DRB Application No.: 03-00290 (SBP) and 03-00291 (P&F)

Project Name: EAST END ADDITION

## DEVELOPMENT REVIEW BOARD TRANSPORTATION DEVELOPMENT Standard Comment Sheet

**DEVELOPMENT REVIEW BOARD--SPEED MEMO**

SITE PLAN

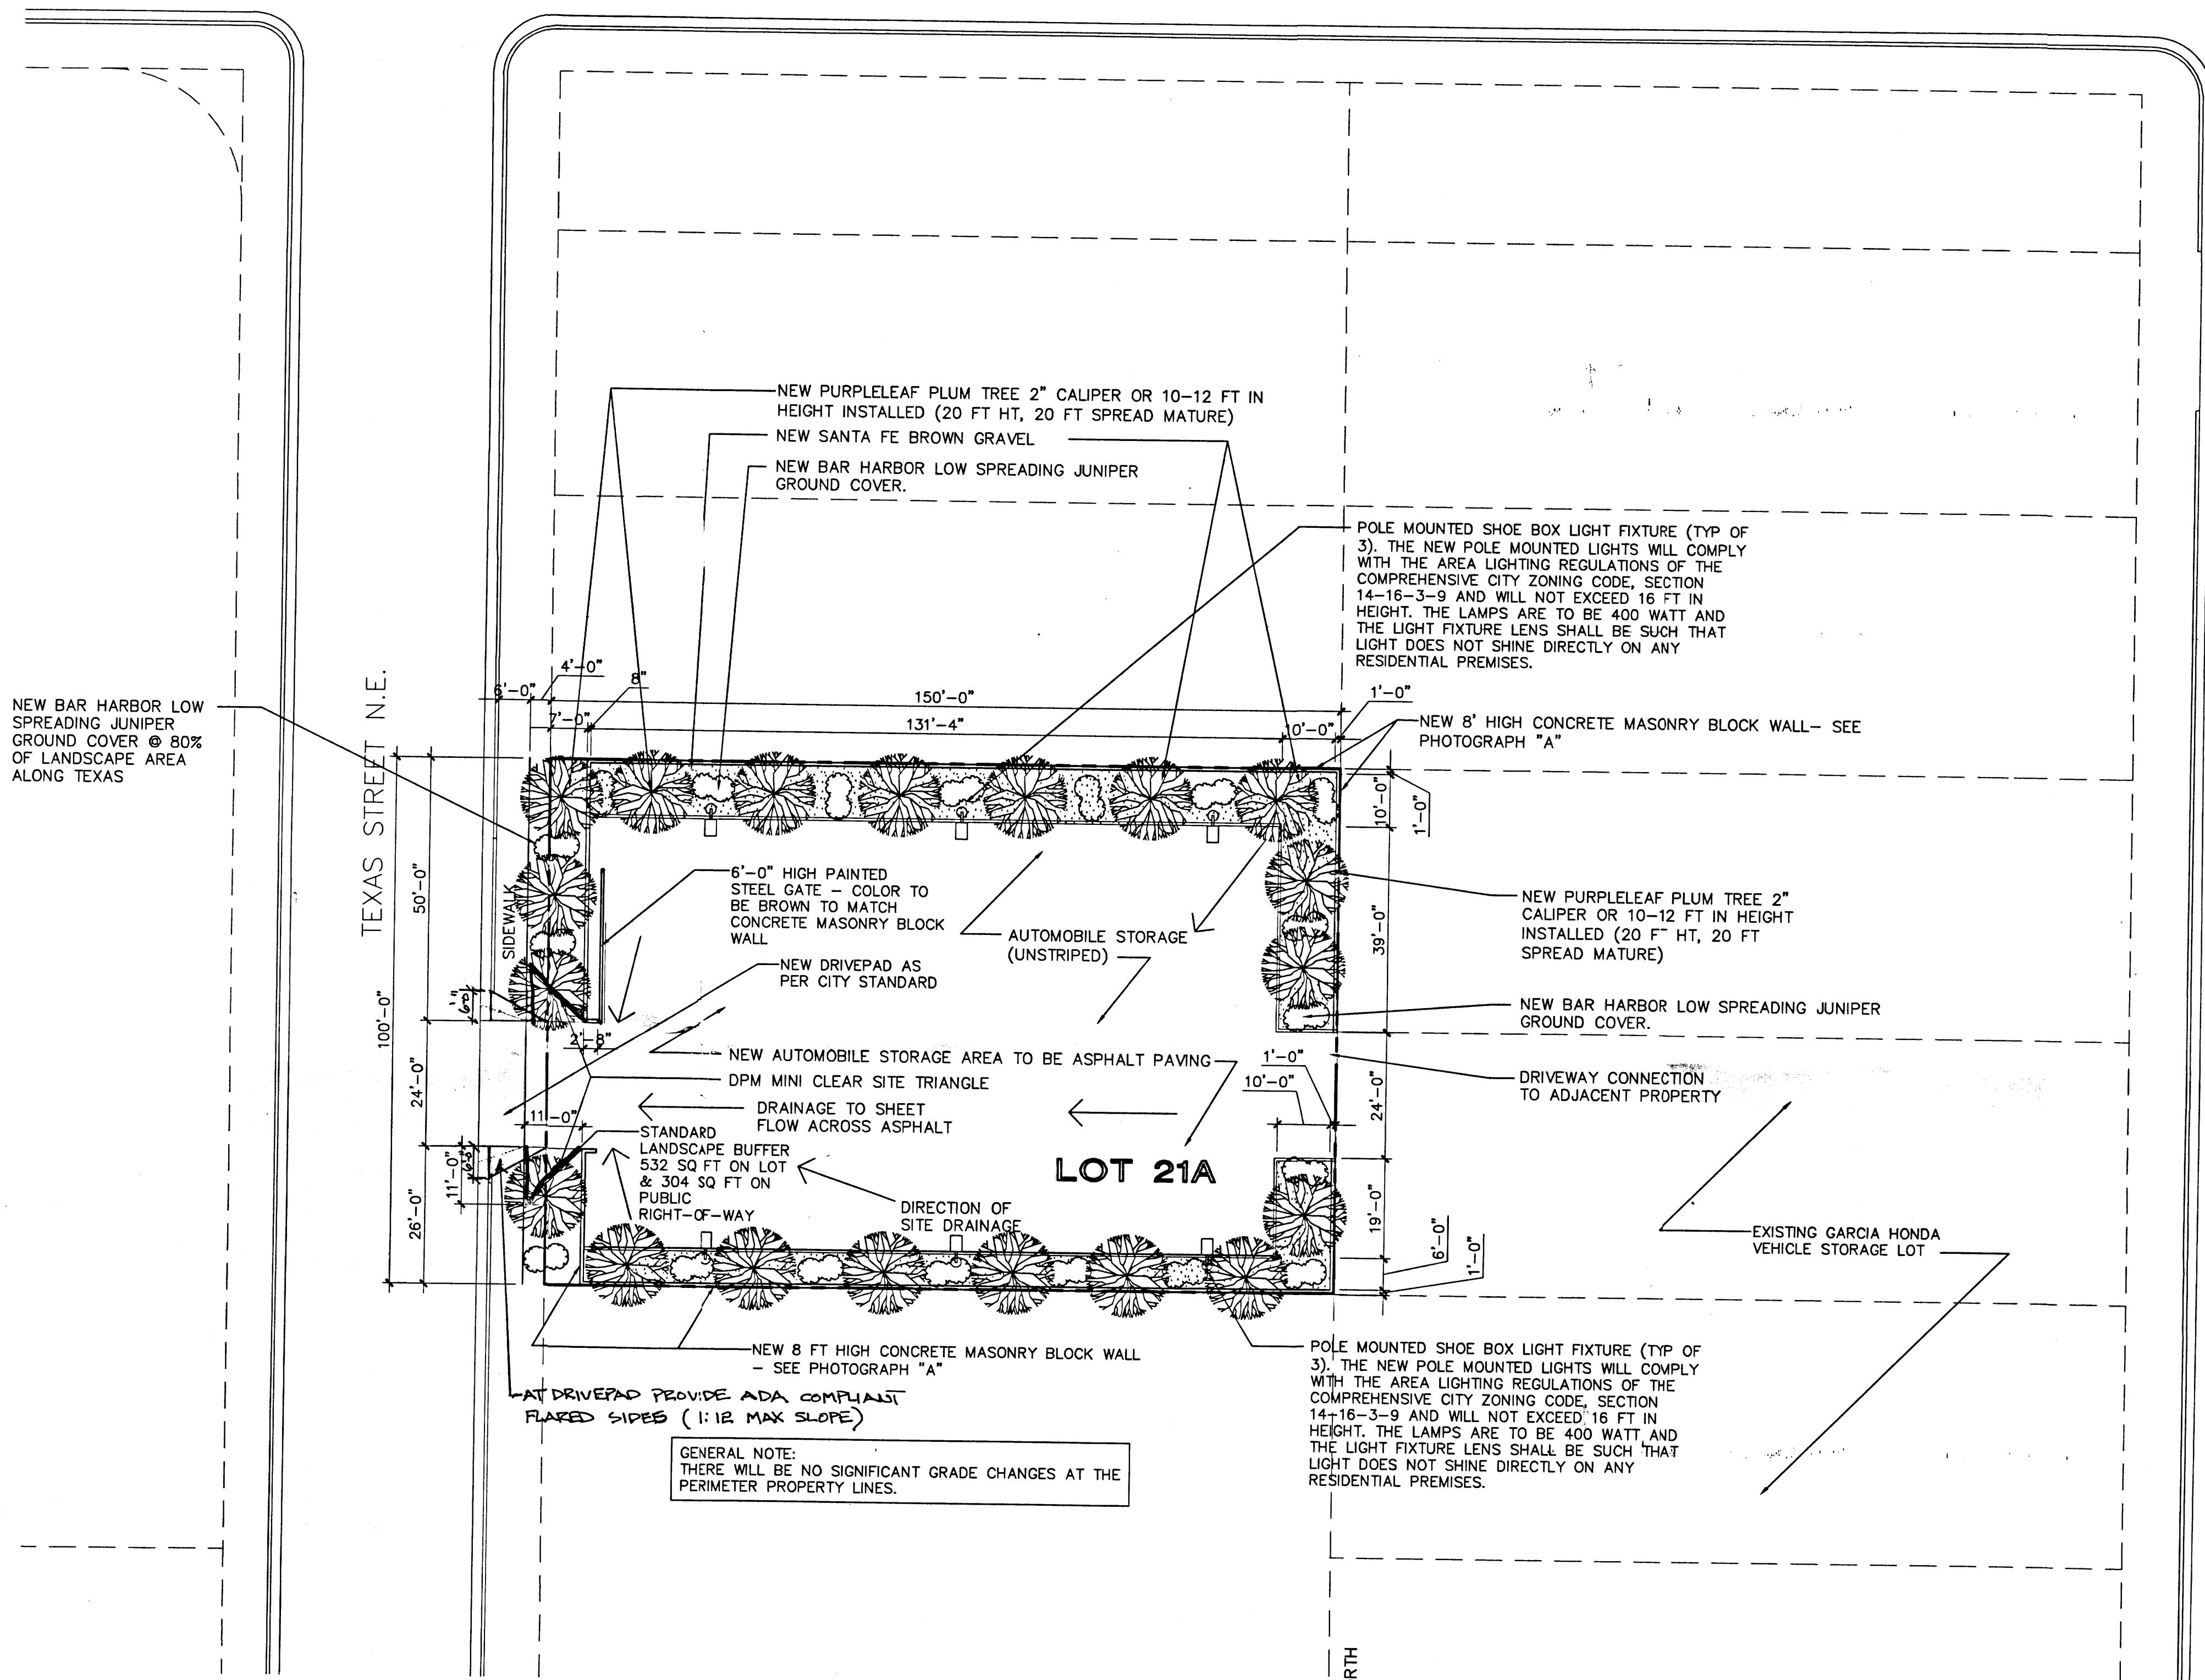
No.	Comment
<input type="checkbox"/>	Show a City Standard ADA drivepad.
